From: Laura Gibbons <Laura.Gibbons@arun.gov.uk>
Sent: 01 July 2021 14:55
To: Planning.Responses <Planning.Responses@arun.gov.uk>
Cc: Simon Davis <Simon.Davis@arun.gov.uk>
Subject: RE: Planning Re-Consultation on: Y/58/21/DOC

Application No: Y/58/21/DOC

Site Address: Stakers Farm North End Road Yapton BN18 0DU

Description of Works: Approval of details reserved by condition imposed under Y/44/17/OUT relating to conditions 6-tree protection, 7-drainage strategy, 8-surface water drainage, 9-maintenance & management of SuDS system, 10-Construction Management Plan, 11-contamination risk, 12-high speed broadband & 25-decentralised & renewable low carbon energy source.

N:\19-156 - Land at Stakers Farm, Yapton\Tech\Acad\Figures\YAP-130-SK005 Swale Sections.dwg

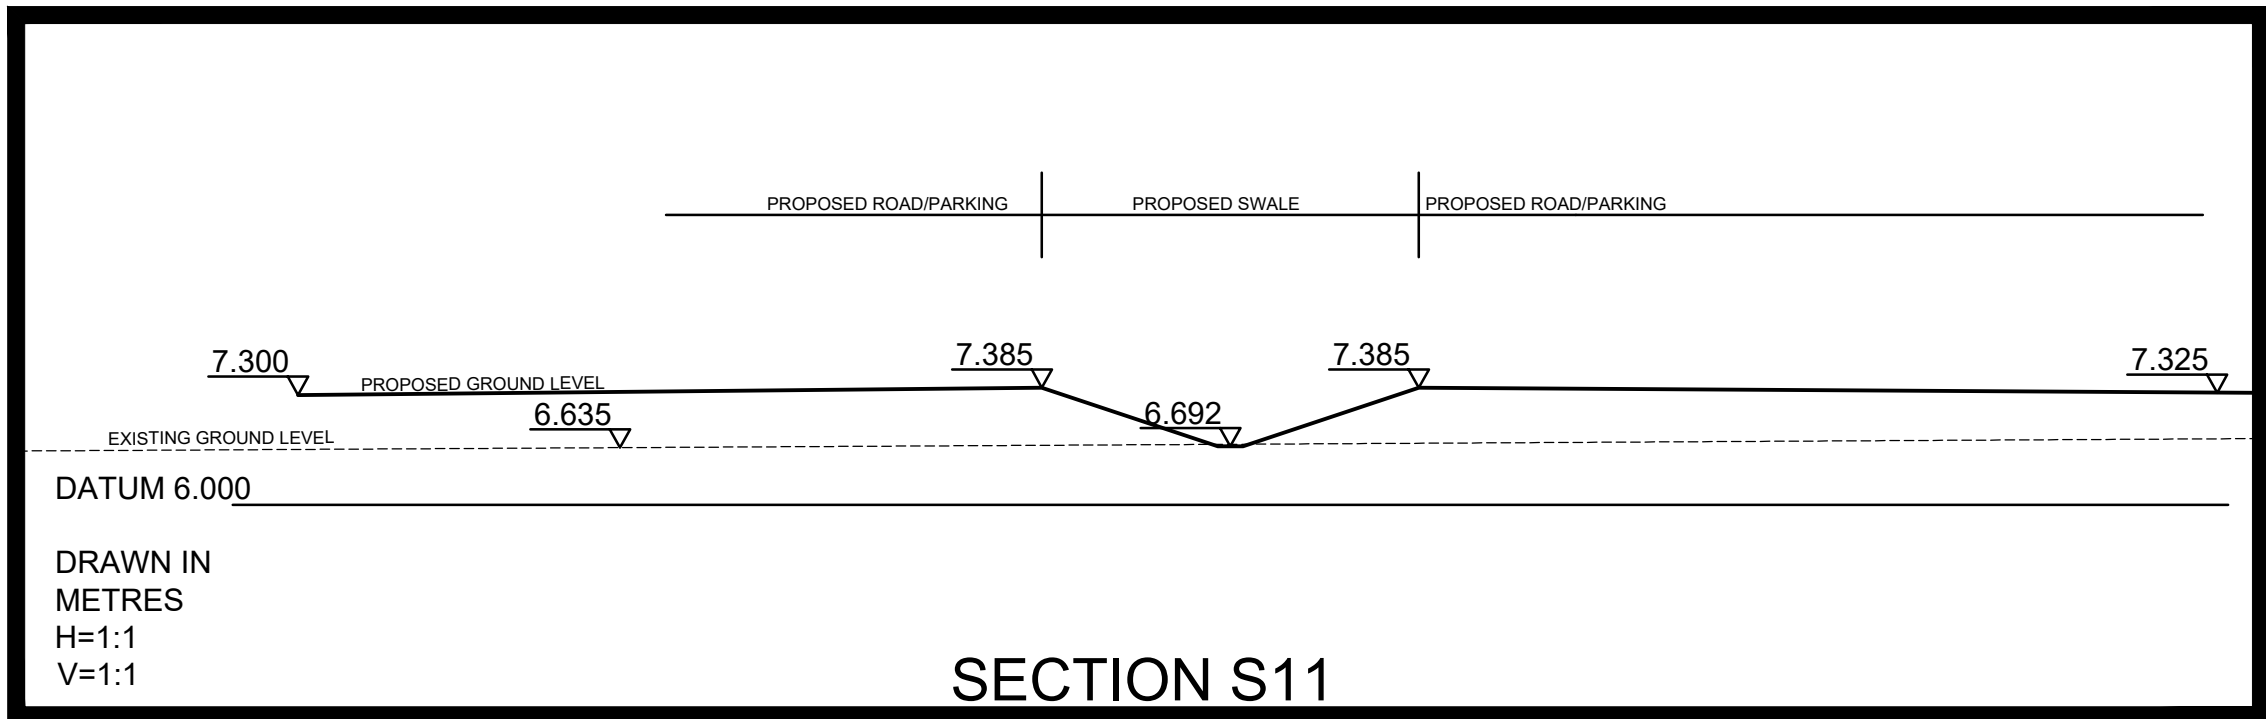
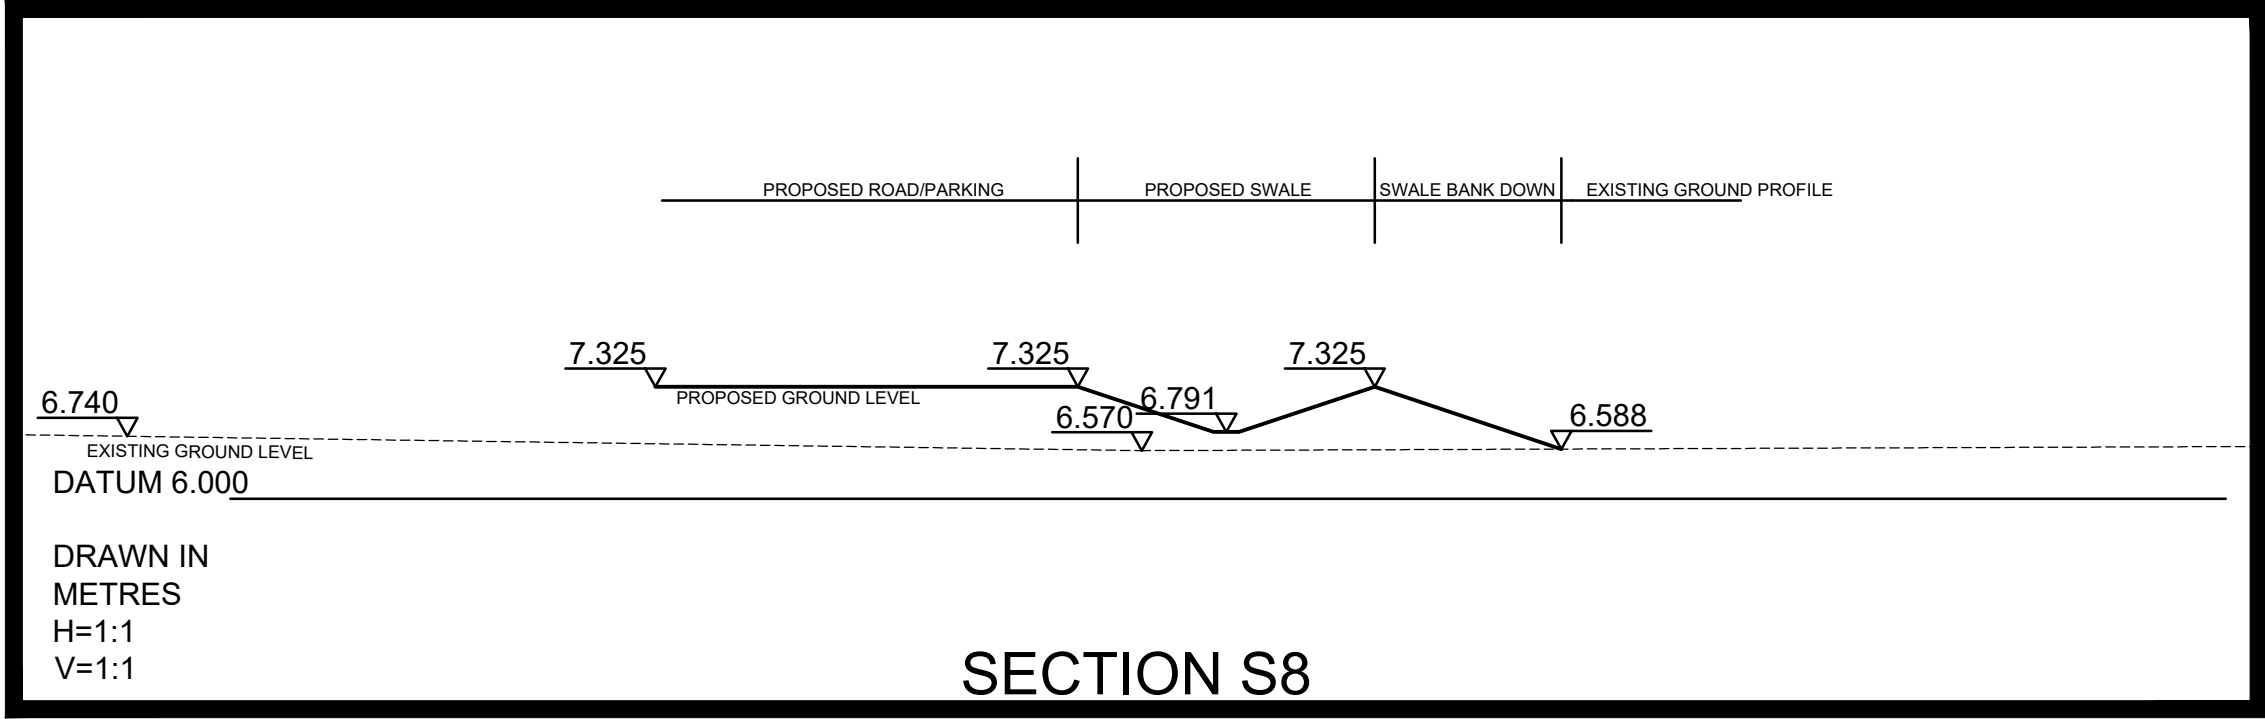
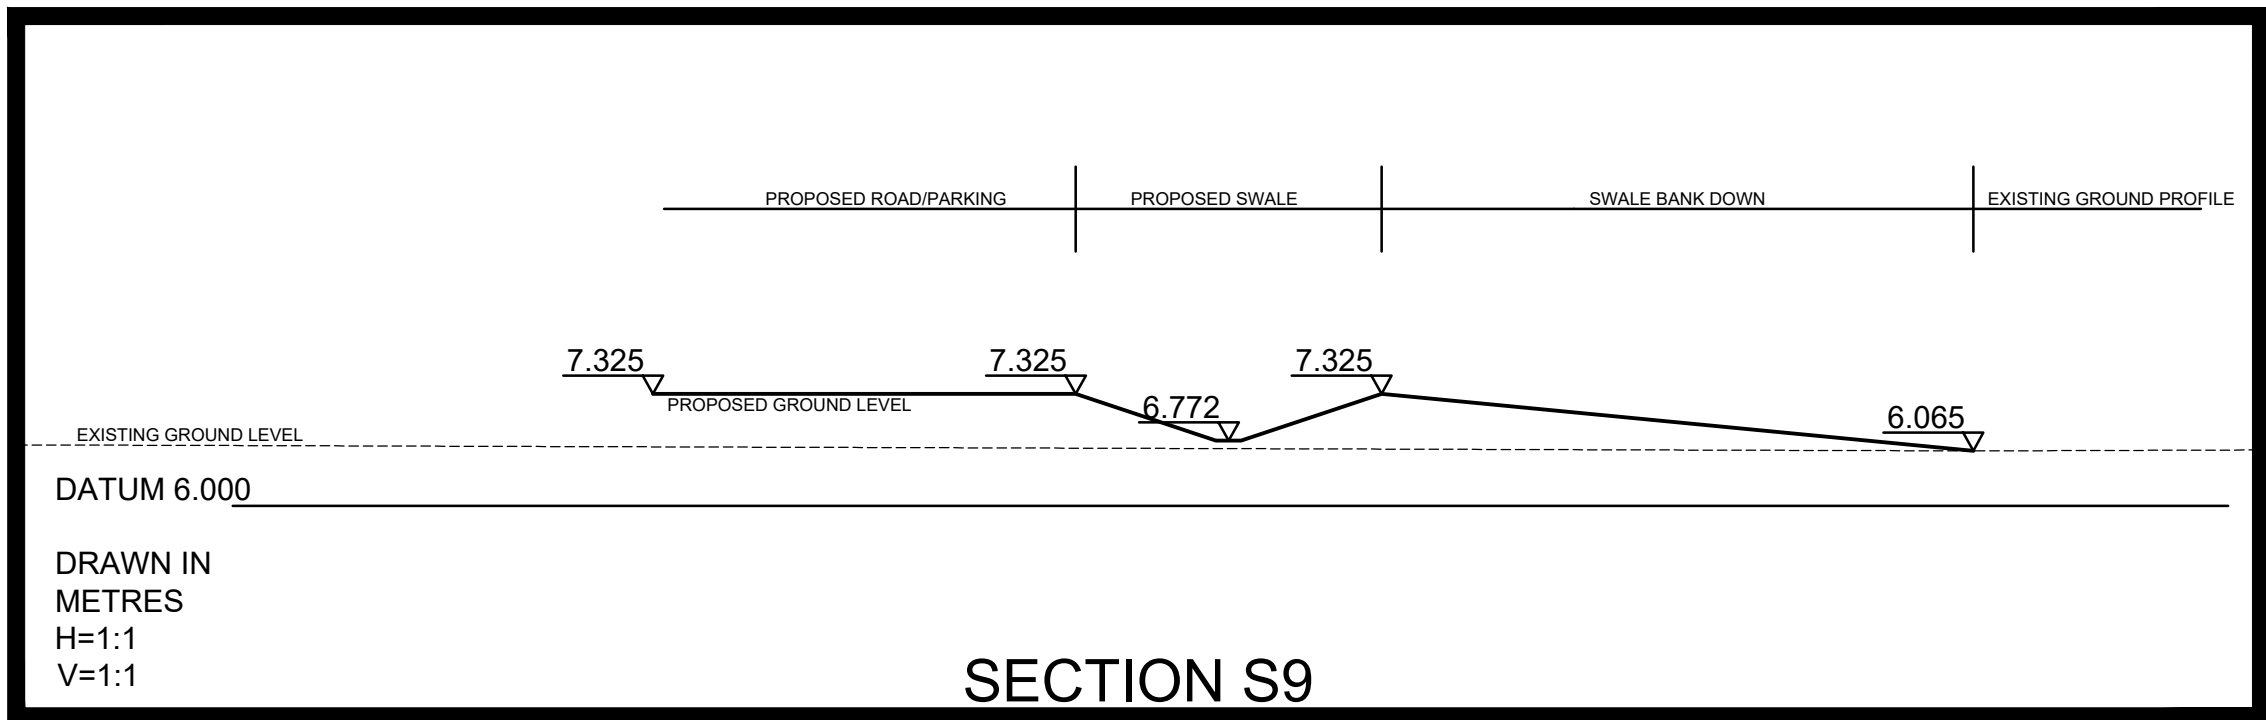
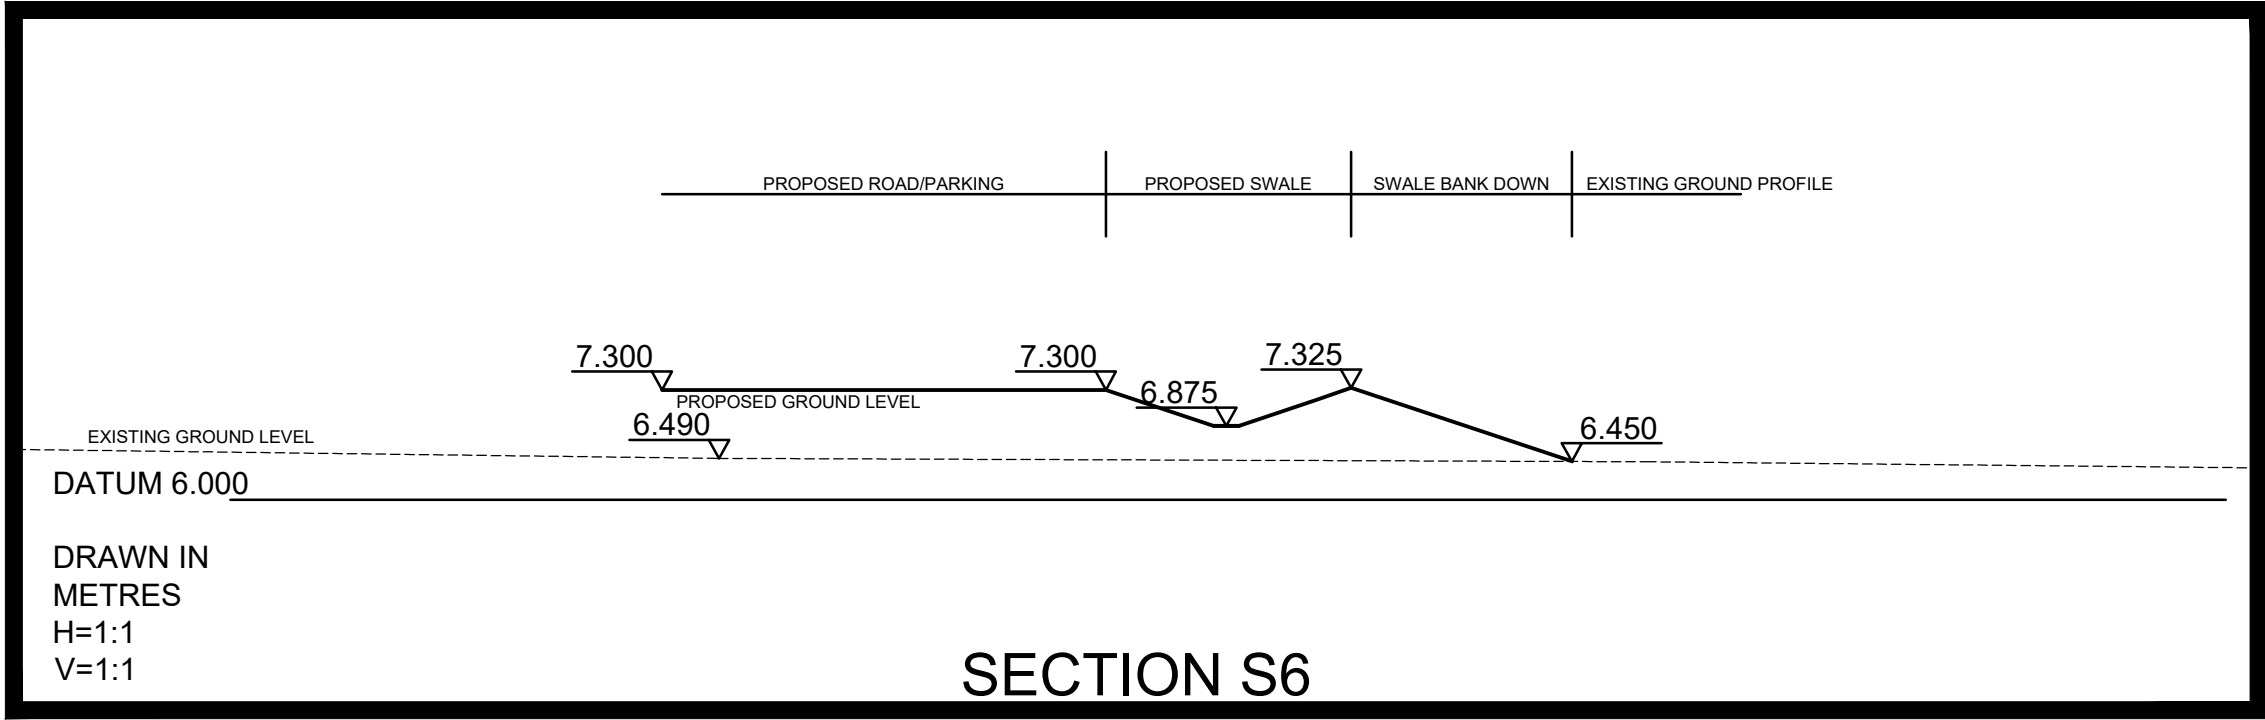
4. Please provide swale cross sections and a long section. Please refer to drawing YAP-130-SK005
5. TP4 has an infiltration rate labelled as $1.8 \times 10^{-6} \text{m/s}$, and this appears to have been used in calculations. The worst case infiltration rate at this location was $1.7 \times 10^{-6} \text{m/s}$. BRE365 test results represented on drawing were based on worst case February results, whereas Arun DC comments refer to March results – TP4 from February is not in the same location as TP4 from March. Drawing 'YAP-130-026G' was updated with March BRE365 test location and prefixes are now added to differentiate between February and March locations. *Okay, point closed, thank you for making testing results clearer.*
